CITY OF PORTLAND, MAINE

January 7, 2014

Project Name: Residential townhouse - 6 unit condominium
Project ID: 2013-187
Project Address: 133 York Street
CBL: 44-1-29 &31
Applicant: 133 York, LLC, Applicant
Planner: Jean Fraser

EROSION CONTROL AND LANDSCAPE PLAN

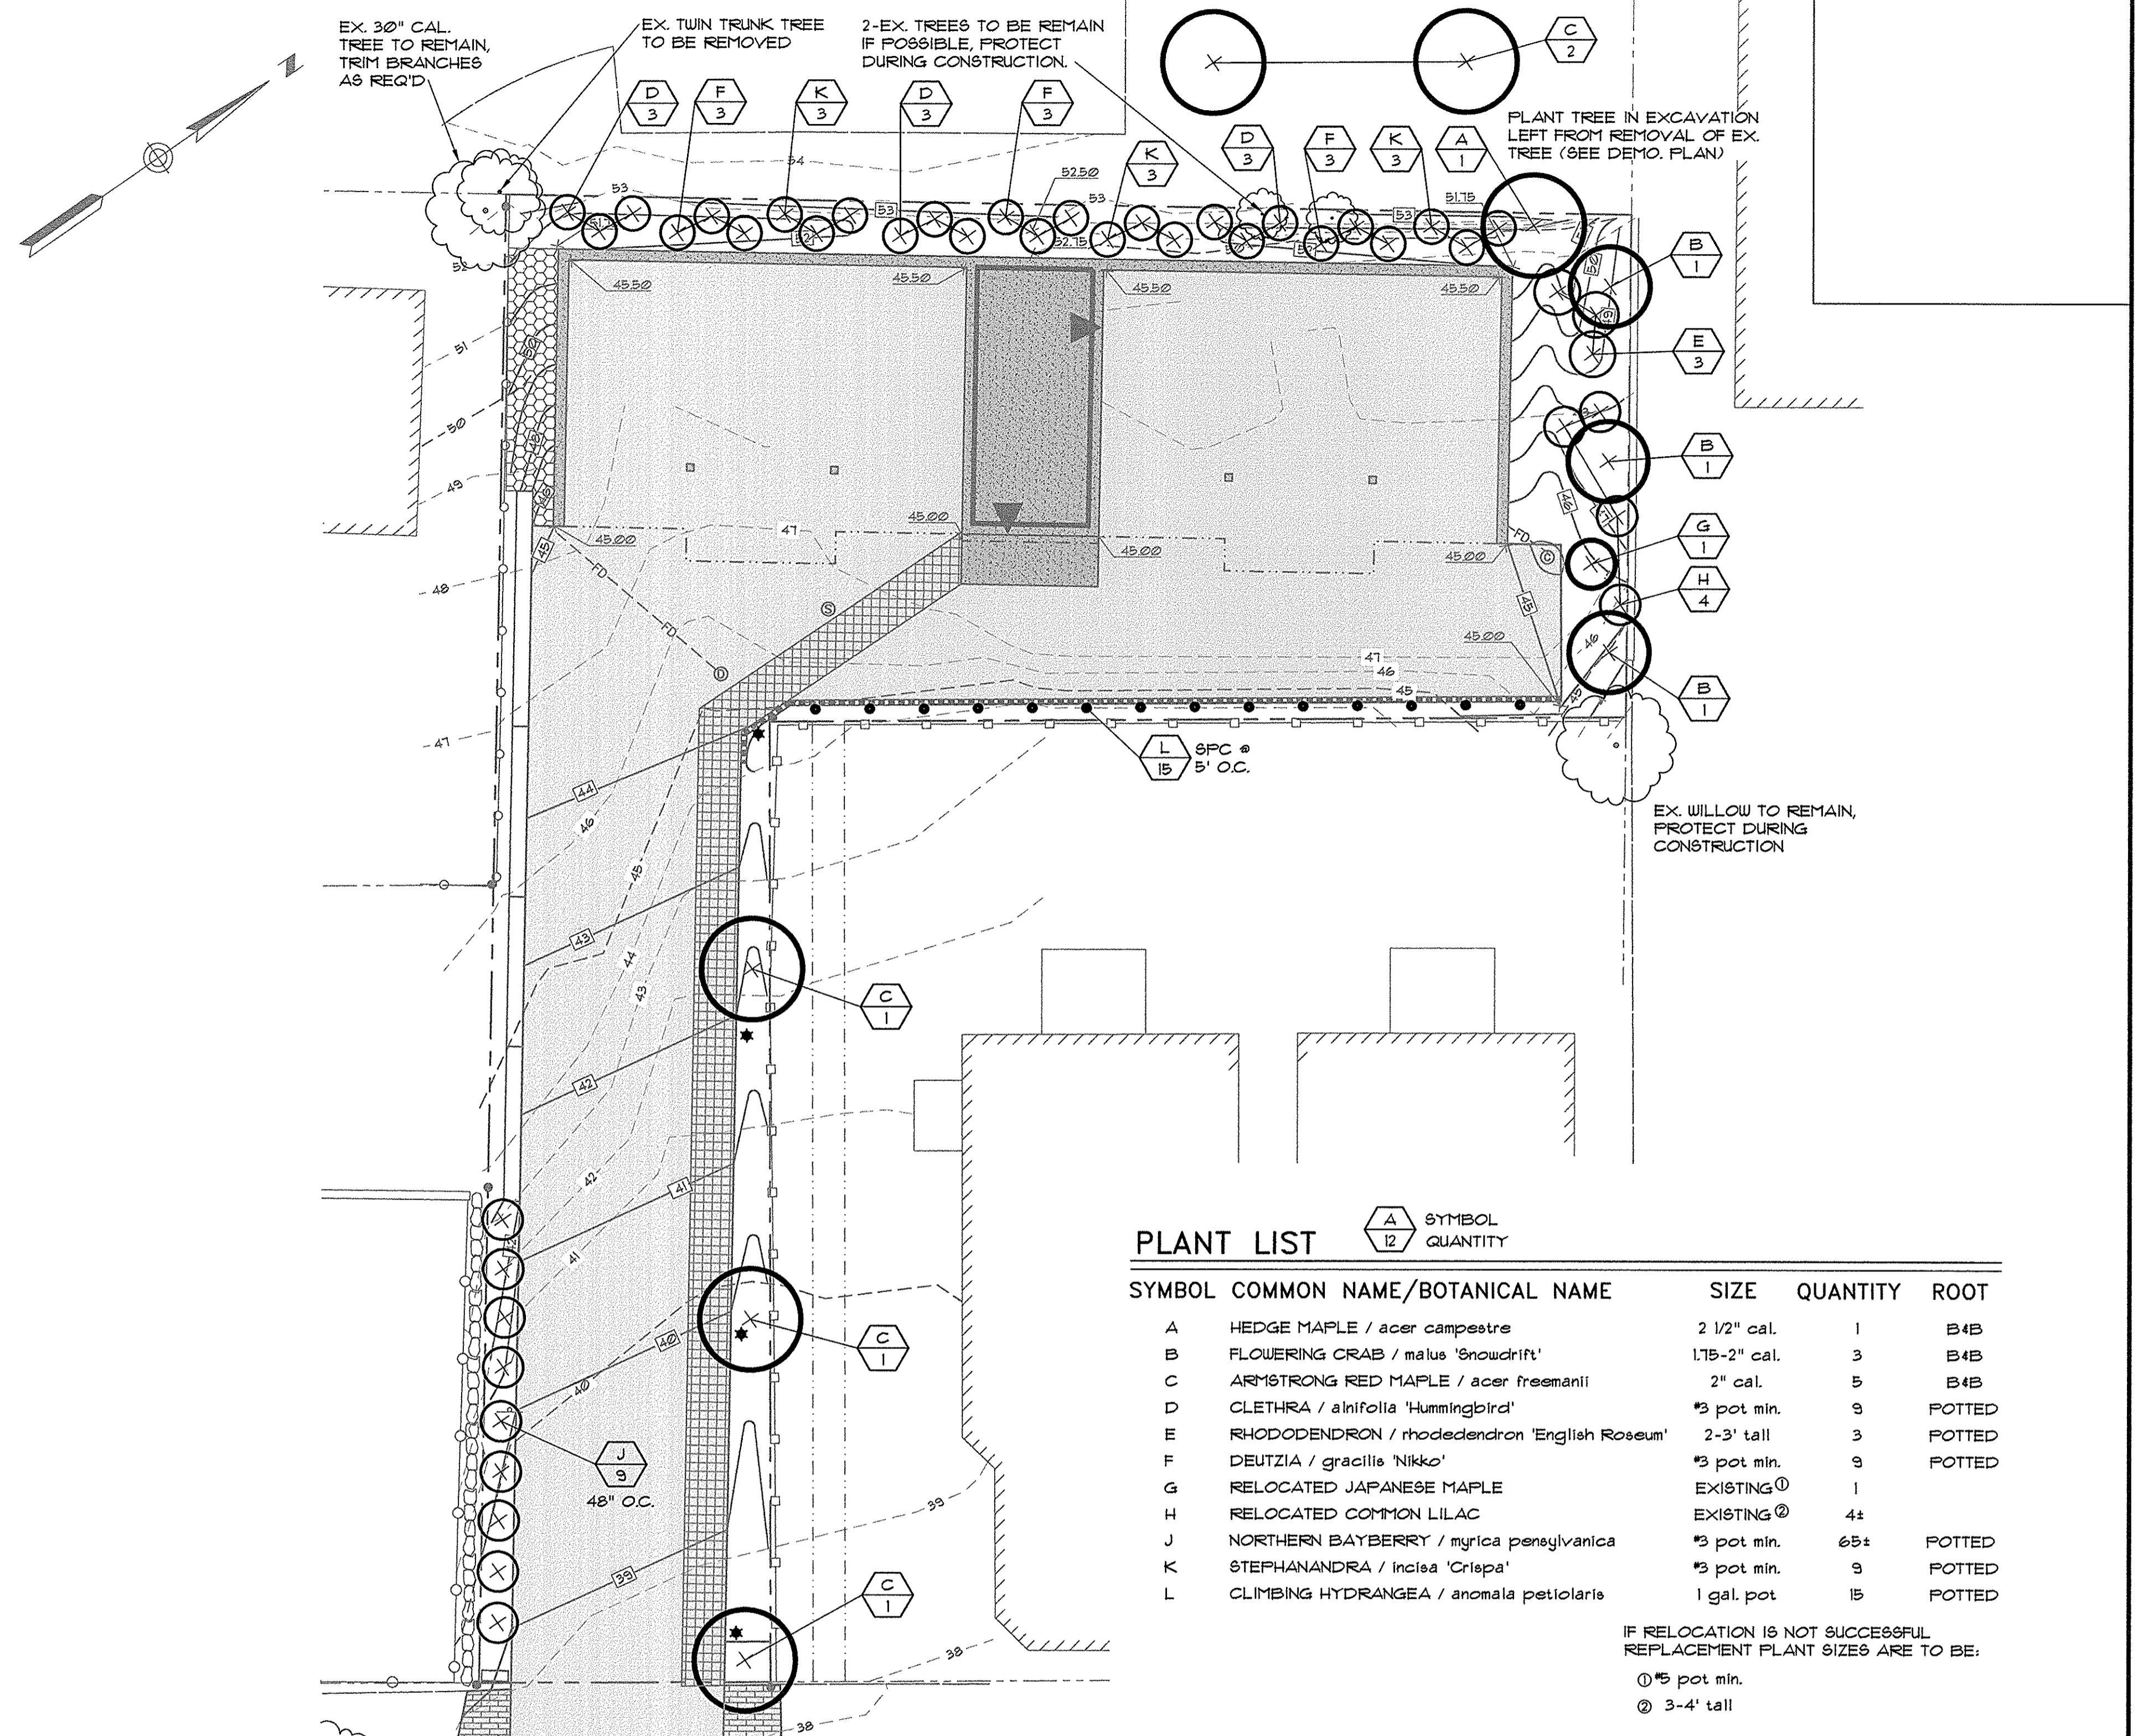
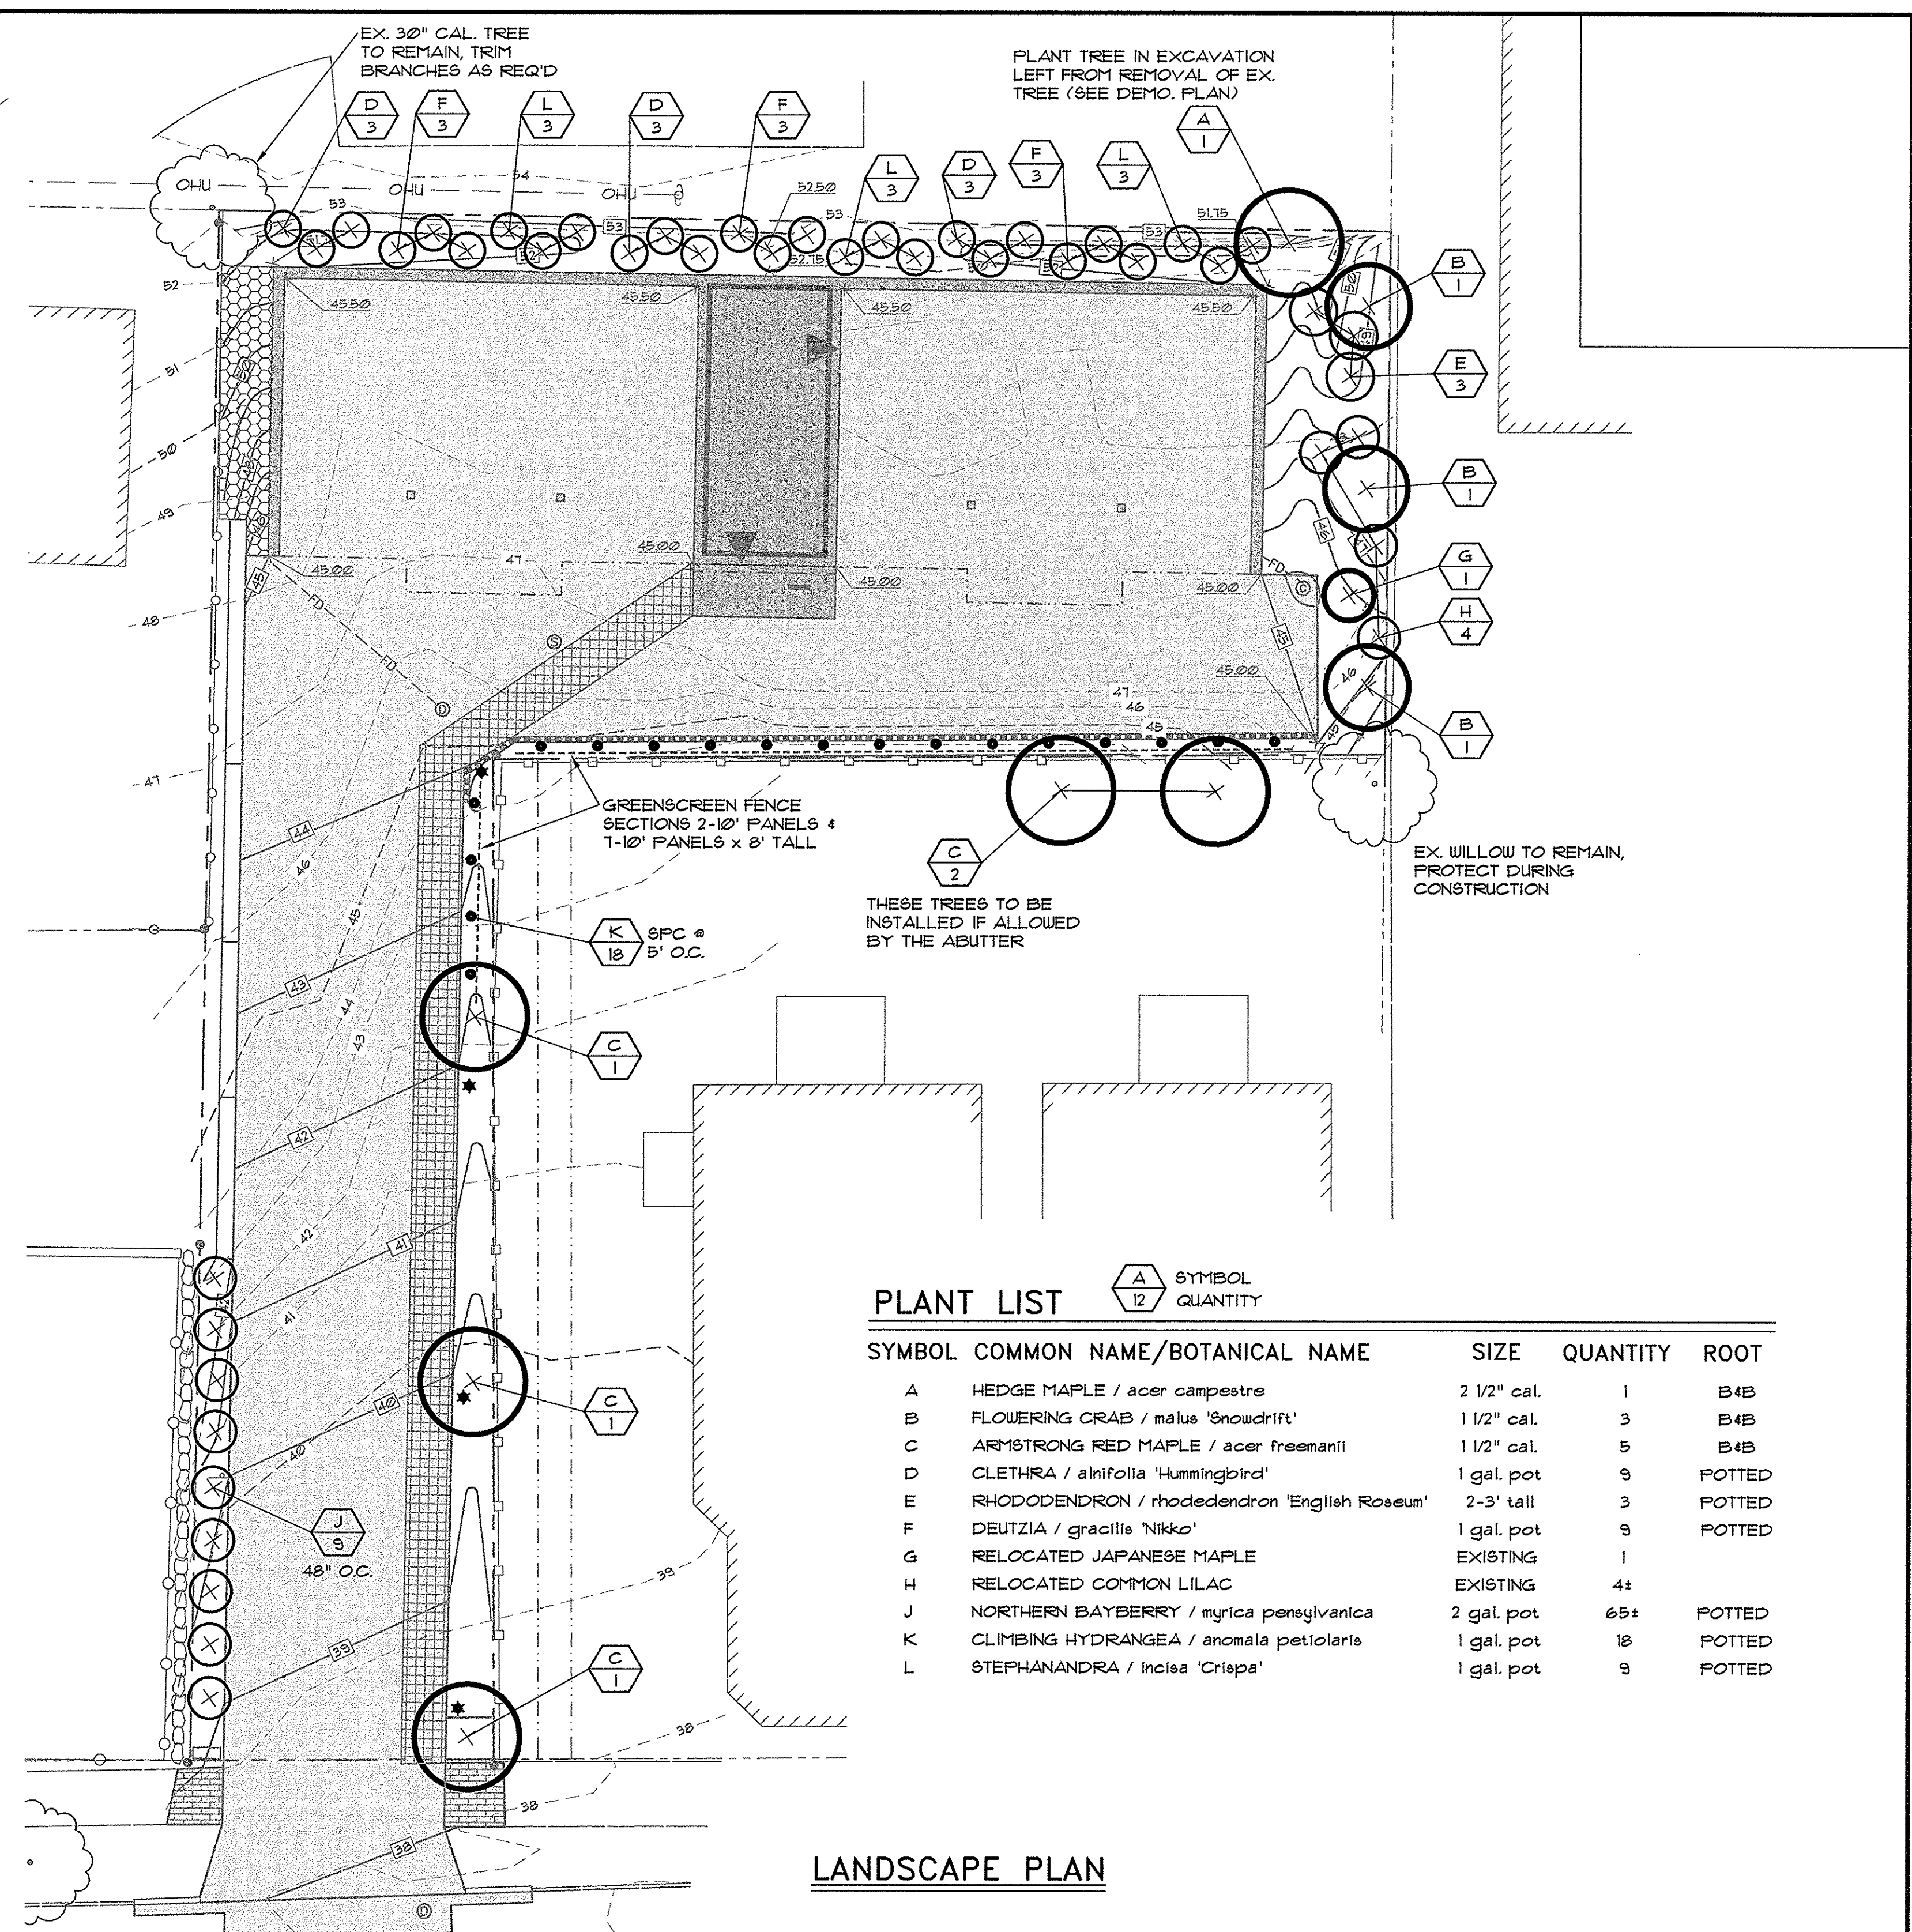
** not received*
- ii. That the applicant shall submit a revised Site Plan, Utility Plan and Landscape Plan that address the 1.23.2014 City Arborist comments in respect of planting materials, and include documentation of fencing details on the south and west boundaries and utility modifications on and near the north boundary, for review and approval by the Planning Authority, Department of Public Services and City Arborist prior to the issuance of a building permit; and
done

1  
A-001  
**GROUND FLR PLAN**  
Scale: 1/4" = 1'-0"

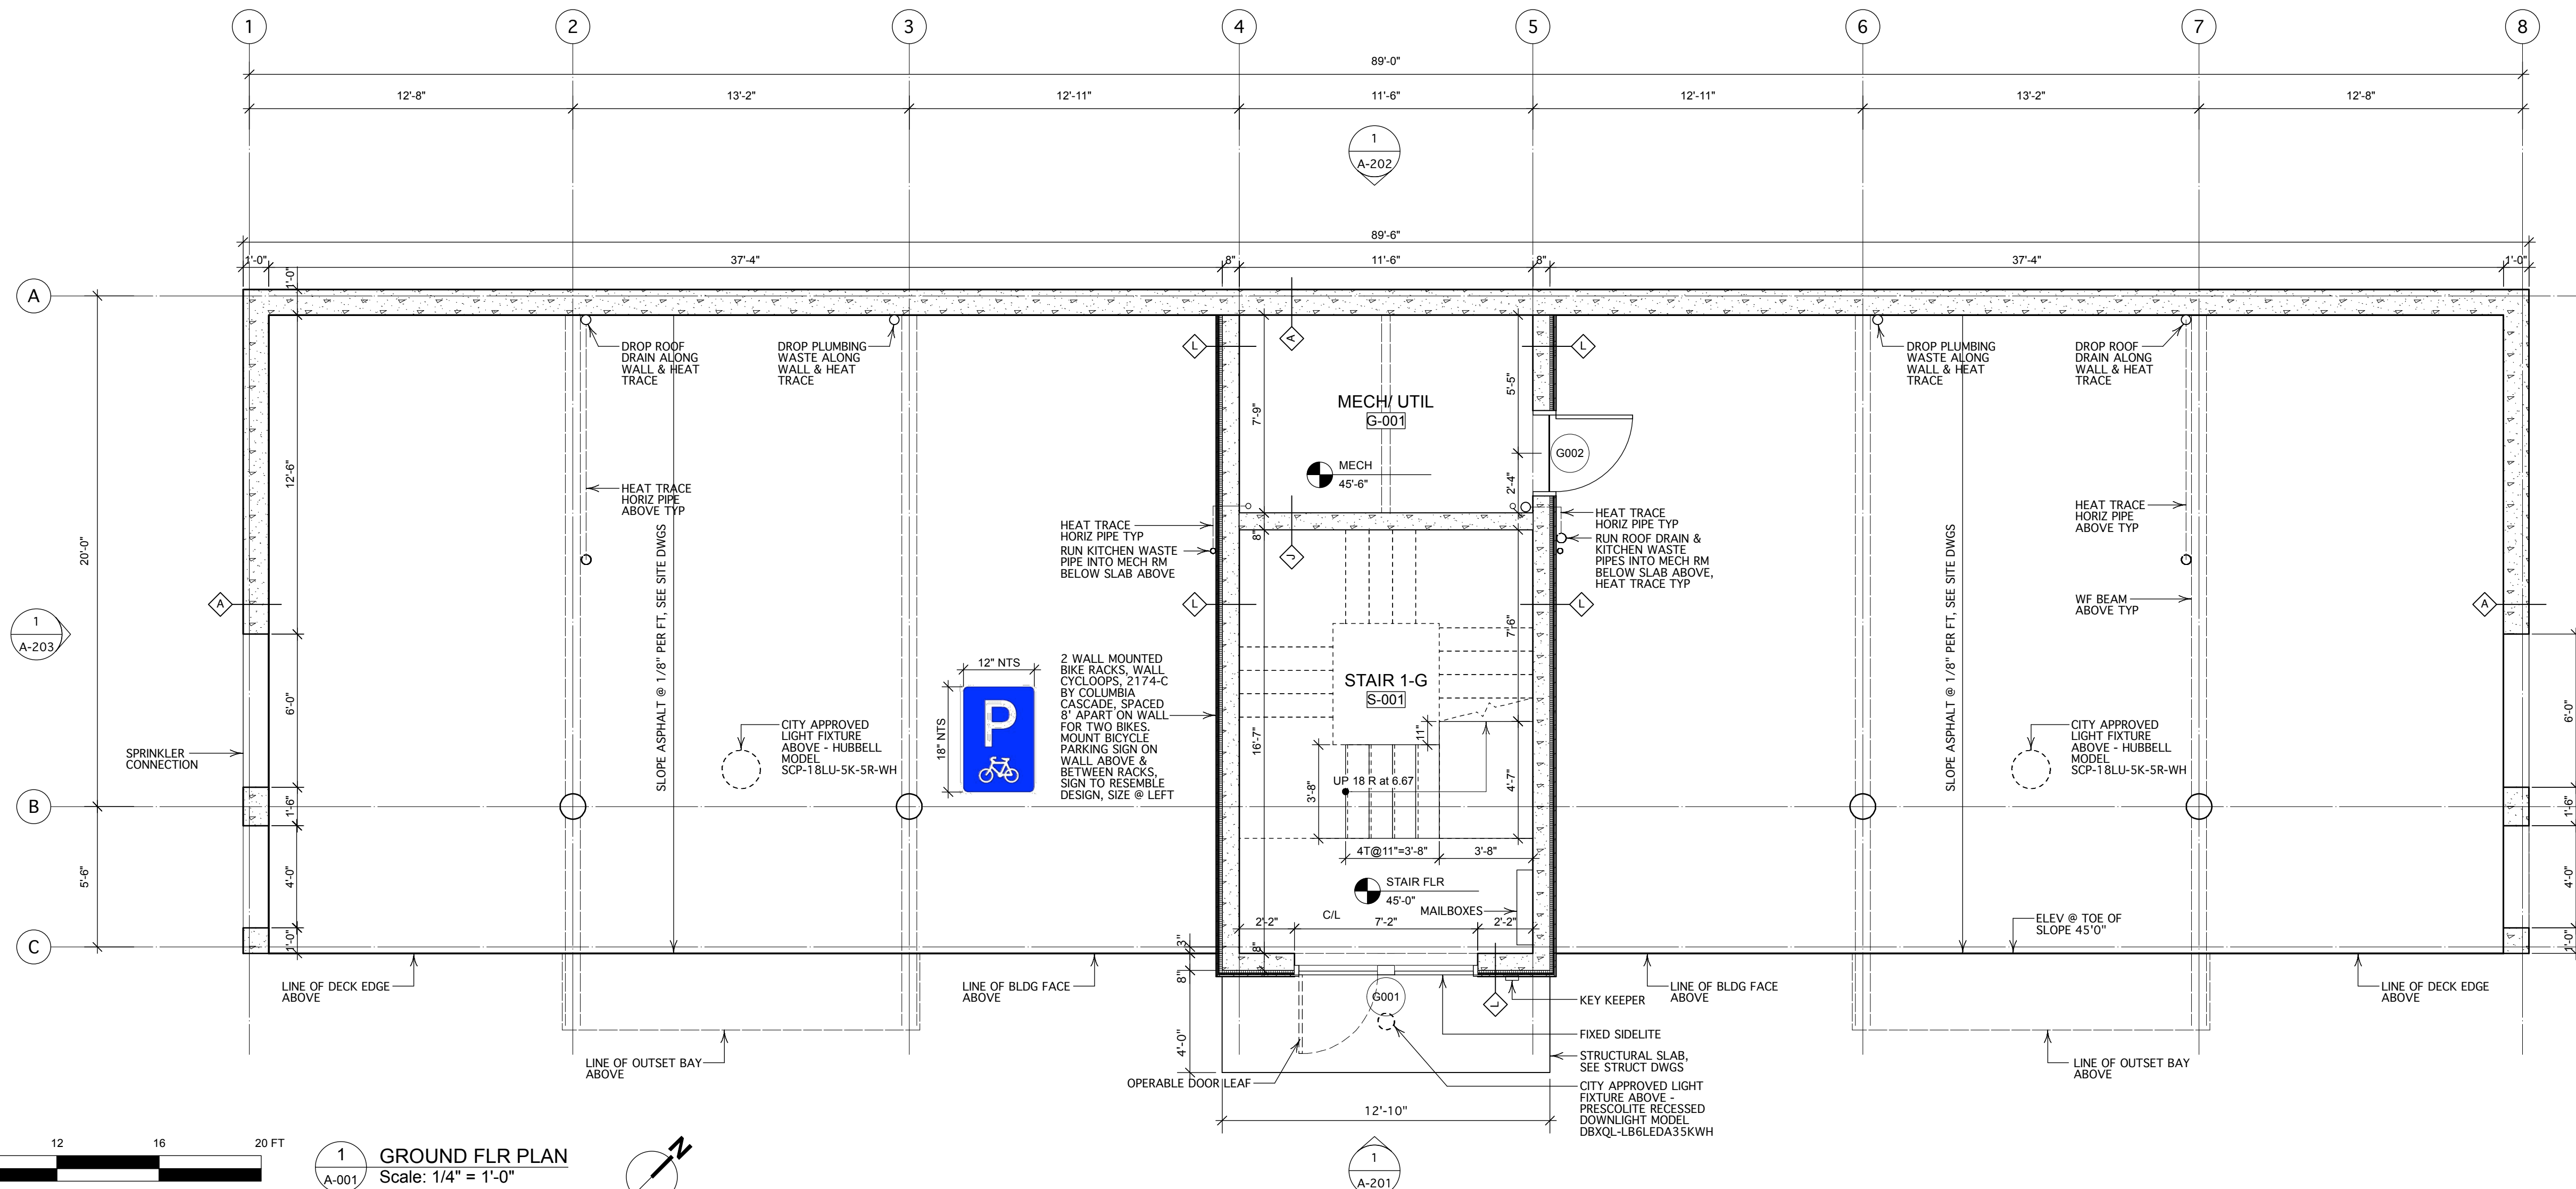
* not seen plan showing relocation

vi. That the applicant shall reconsider the location of the bicycle parking rack so that it does not impede access to parking spaces and is readily visible and accessible to potential users, with a plan showing the revised location to be reviewed and approval by the Planning Authority prior to the issuance of a building permit; and
